CITY OF MERCER ISLAND

RE: Notice of Incompleteness for File No. SUB21-006 – Milestone Short Subdivision
7621 SE 22nd ST, Mercer Island, WA 98040; King County Tax Parcel # 531510-1846

The City of Mercer Island received the above referenced application for a three (3) lot short subdivision for the property located at 7621 SE 22nd ST (King County parcel # 531510-1846) on June 23, 2021. The City has assigned file number SUB21-006 to the short subdivision application. Following review of the application, City staff has determined that the application is **incomplete**, and the following items need to be provided:

MILESTONE PRELIMINARY SHORT PLAT

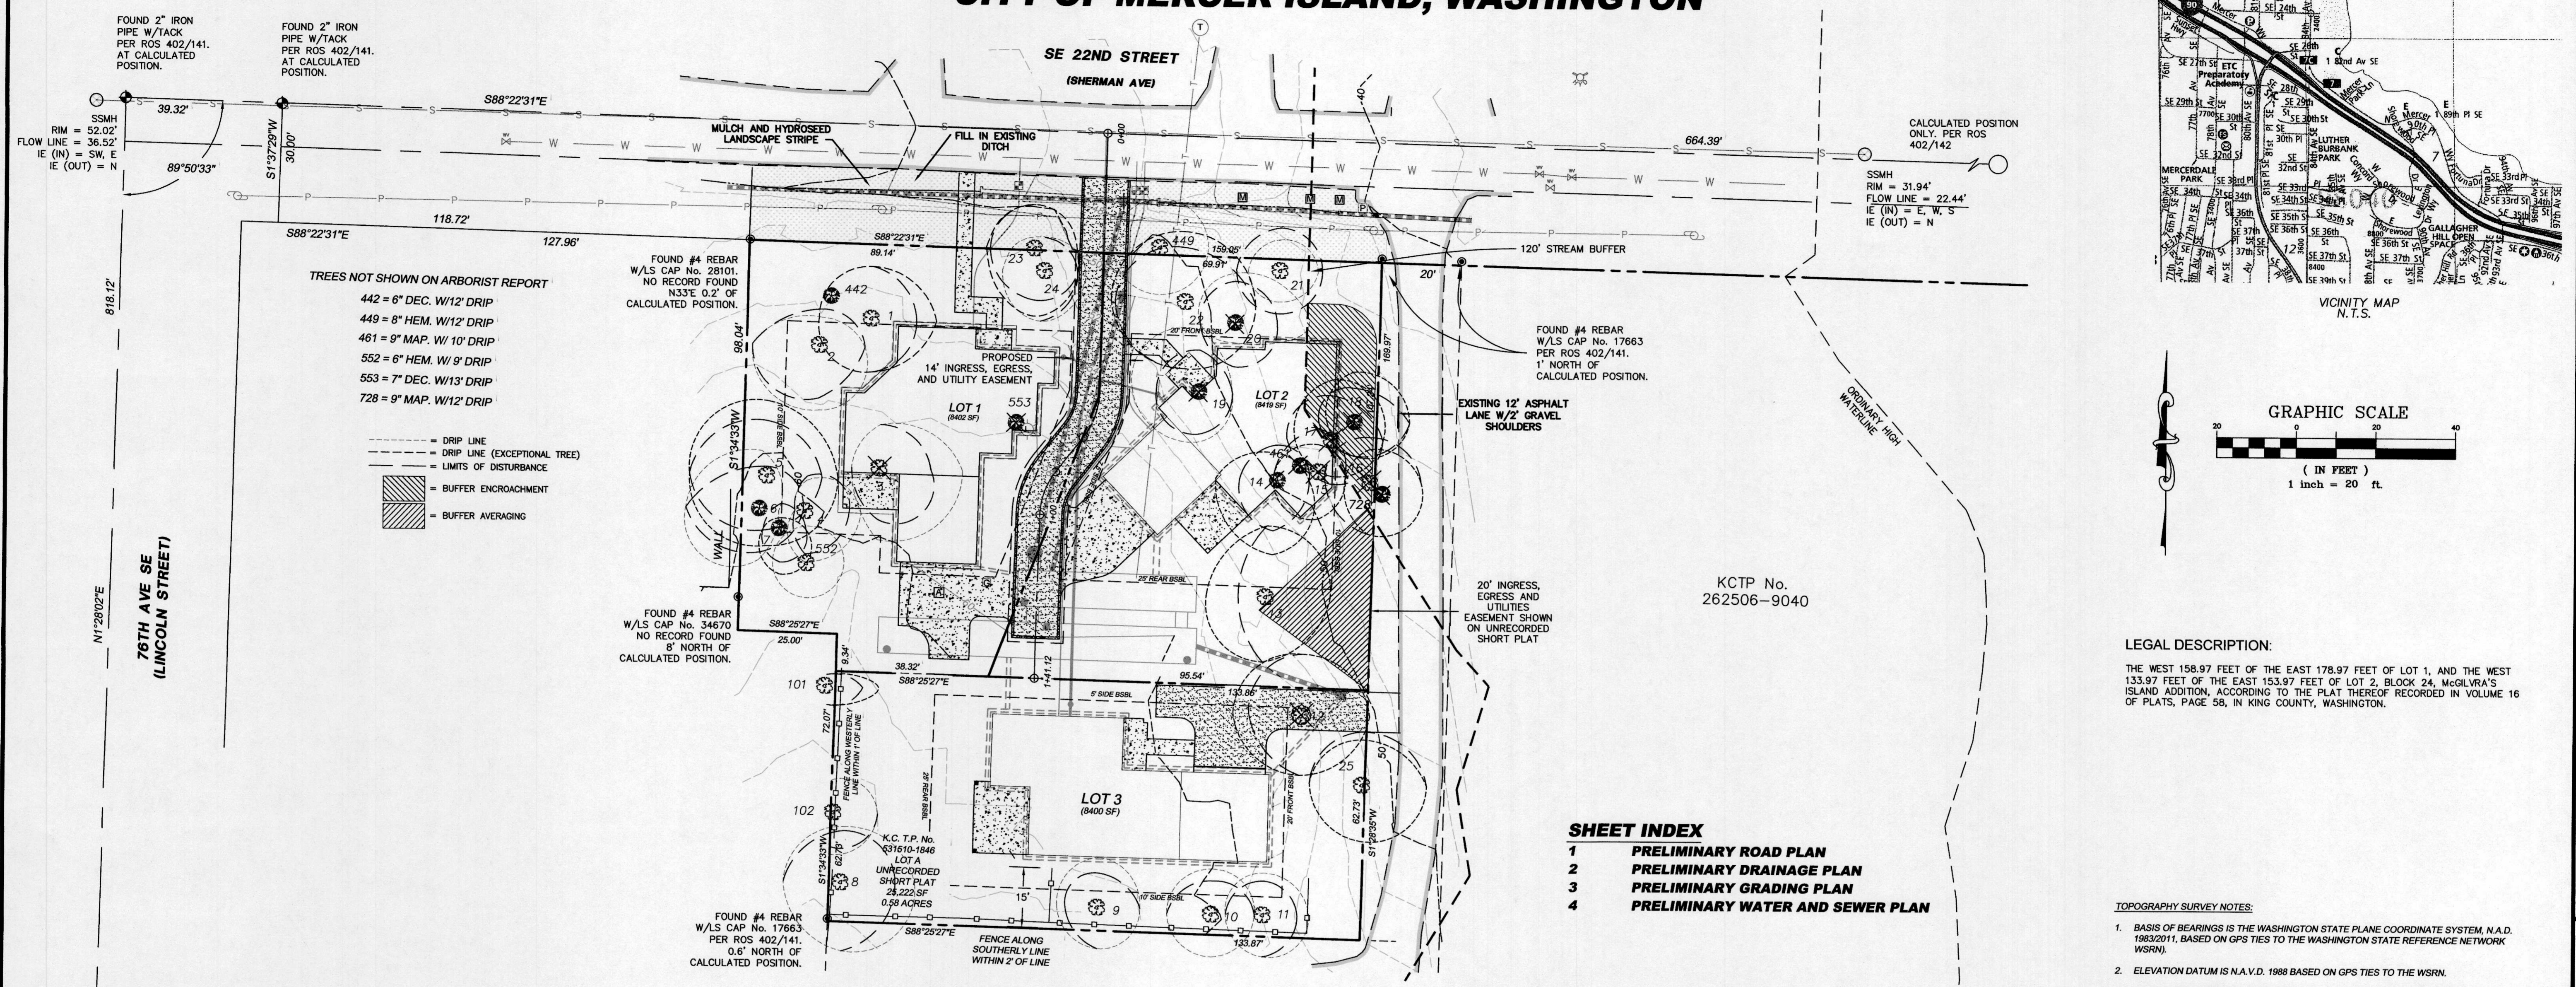
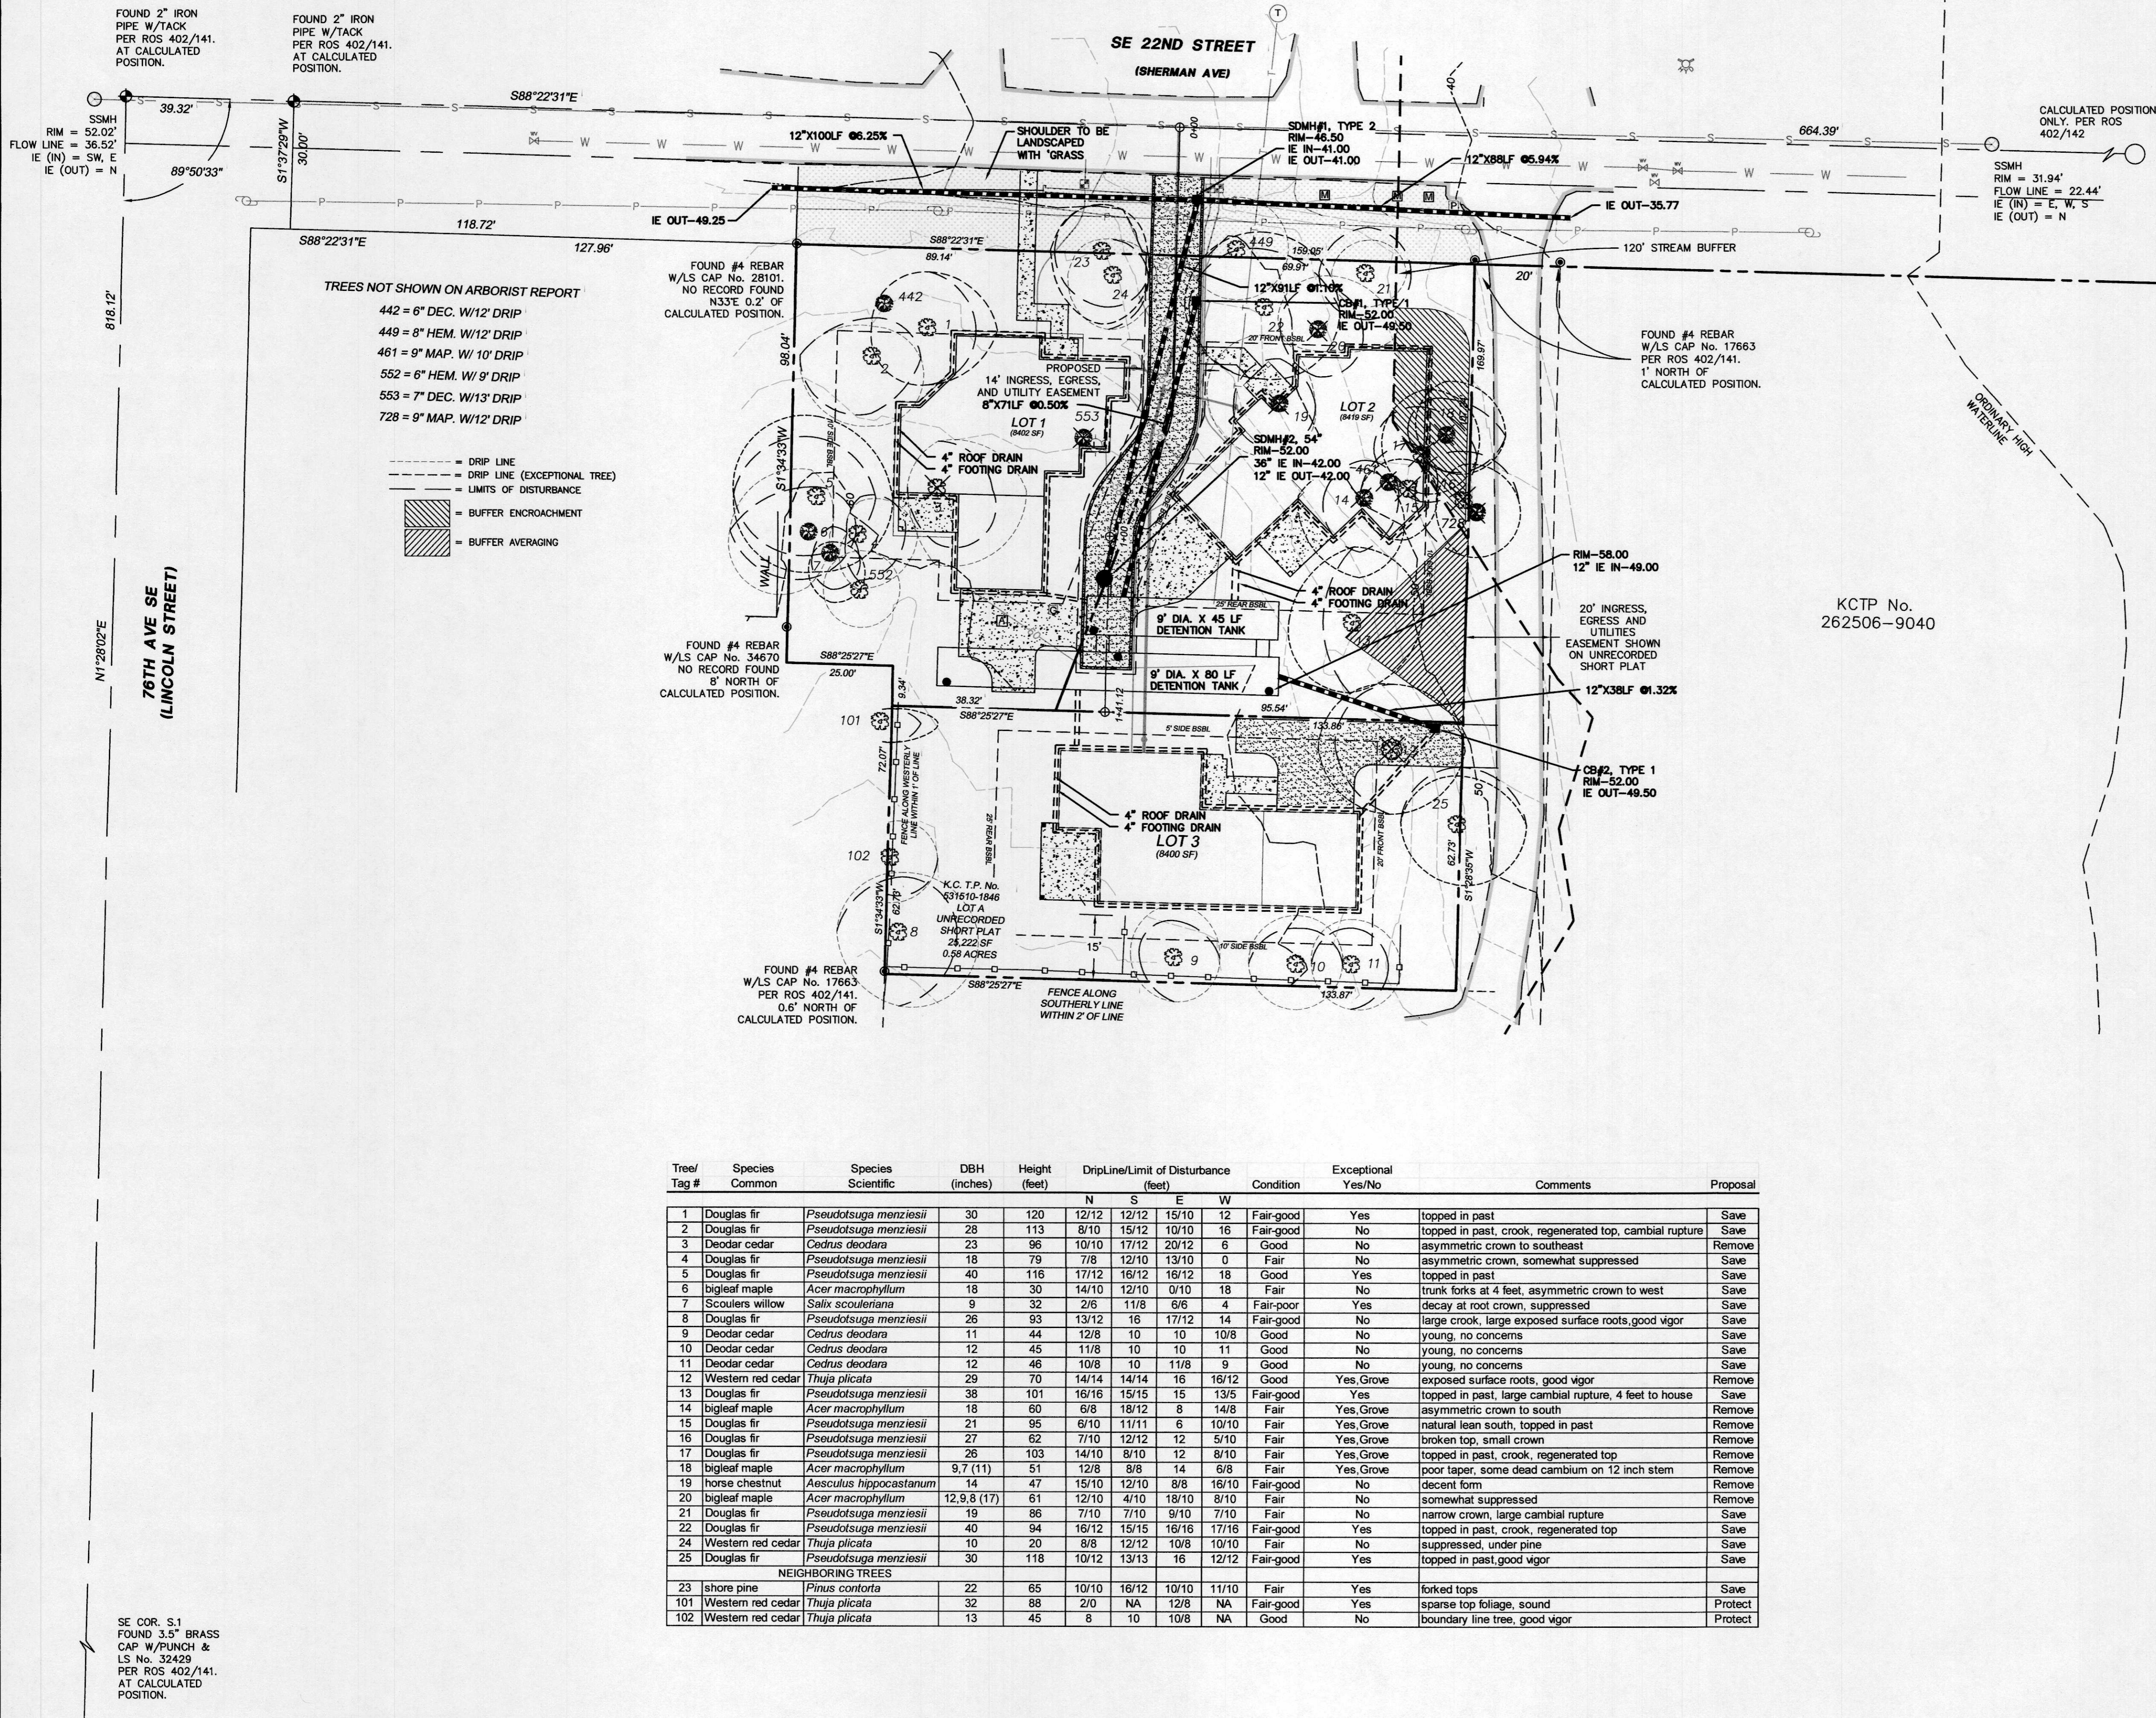
3. Civil: See checklist for tree protection plan. Use Arborist report to complete plan. Create tree protection plan with dripline of all trees even those proposed for removal.
https://www.mercerisland.gov/sites/default/files/fileattachments/community_planning_amp_developm ent/page/21988/treessubmittalchecklist.pdf
4. A preliminary replanting plan is recommended at this time to confirm replacements can be fit on either proposed lot. It will be required at the time of building. At least half of the trees need to be Pacific Northwest native. The trees need to be at least 10' apart from each other, structures, fences and utilities. If you can show no room exists on site for all the required trees, the remainder can be a fee in lieu (\$494.50/tree that cannot be replaced). A request form must be completed and approved for this option.

# RAND-MILESTONE 3 LOT PRELIMINARY SHORT PLAT

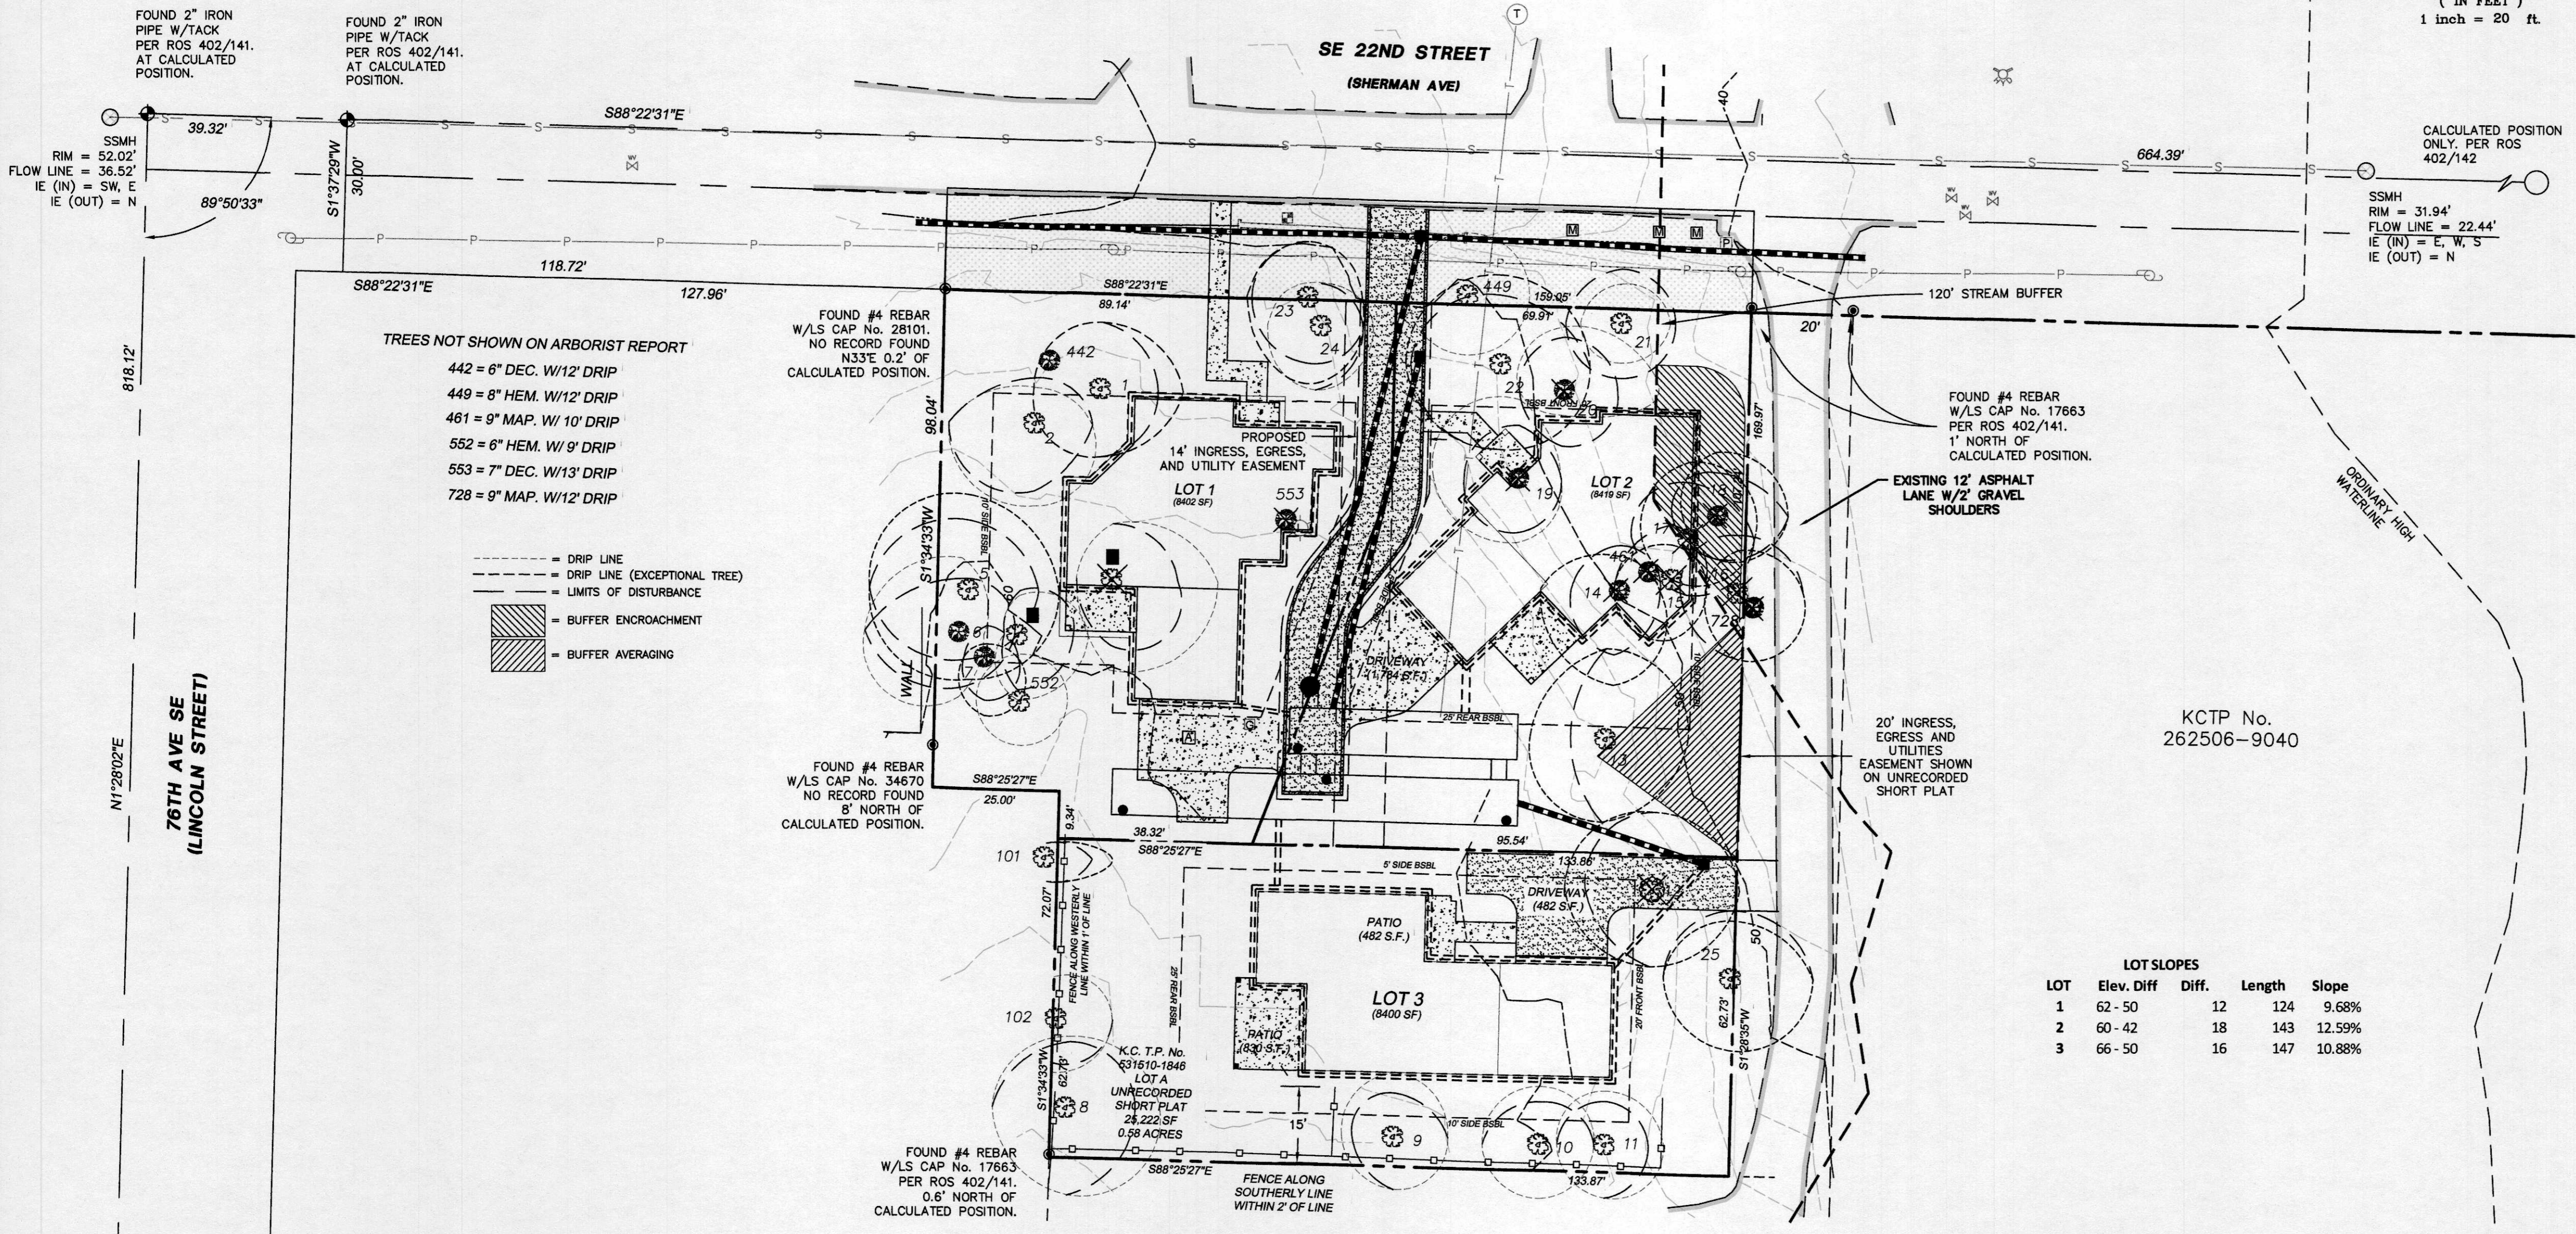
2. Per MICC 19.09.090(A)(2)(c) building pads shall not be located within critical and buffers. The proposed building pad on Lot 2 is within the 120 foot type F watercourse buffer. There are 2 options moving forward:

- a. Revise the plans to have the building pad outside the watercourse buffer and 10 foot setback (see comment #3 below).
 - b. Apply for a Critical Area Review 2 application to do buffer averaging or reduction under MICC 19.07.180(C)(4) or (5). A critical areas study and mitigation plan would be required.

3. Please note that per MICC 19.07.180(C)(7) buildings and other structures shall be set back a minimum of 10 feet from the edge of the 120 foot watercourse buffer.

4. Provide the following information for the existing and proposed lots: Lot width, depth, lot area and net lot area, lot slope, hardscape, and lot coverage.

5. Please note what existing improvements are proposed to be removed (i.e., the existing house, driveway, patio, fence, etc.).
6. This approval note will need to be added (can be addressed now or later):

1. As noted in the pre application meeting, tree 13 is exceptional and dripline is not shown according to Arborist report. A 16' dripline to the north should be shown. Also see Arborist provided Limits of allowable disturbance that must be shown and update for all trees. If these limits are encroached upon the tree would be considered damaged and possibly removed. Unless an Arborist supervised and controlled air excavation root analysis is conducted and finds different results.
2. As noted in the pre application meeting, trees 12-18 and 25 may be an exceptional grove according to the Arborist. Unless shown otherwise all these trees should be considered exceptional and need to be protected. Unless removal is justified under MICC19.10.060.3. This justification of removal is to include a description on how the site was designed to minimize tree removal.
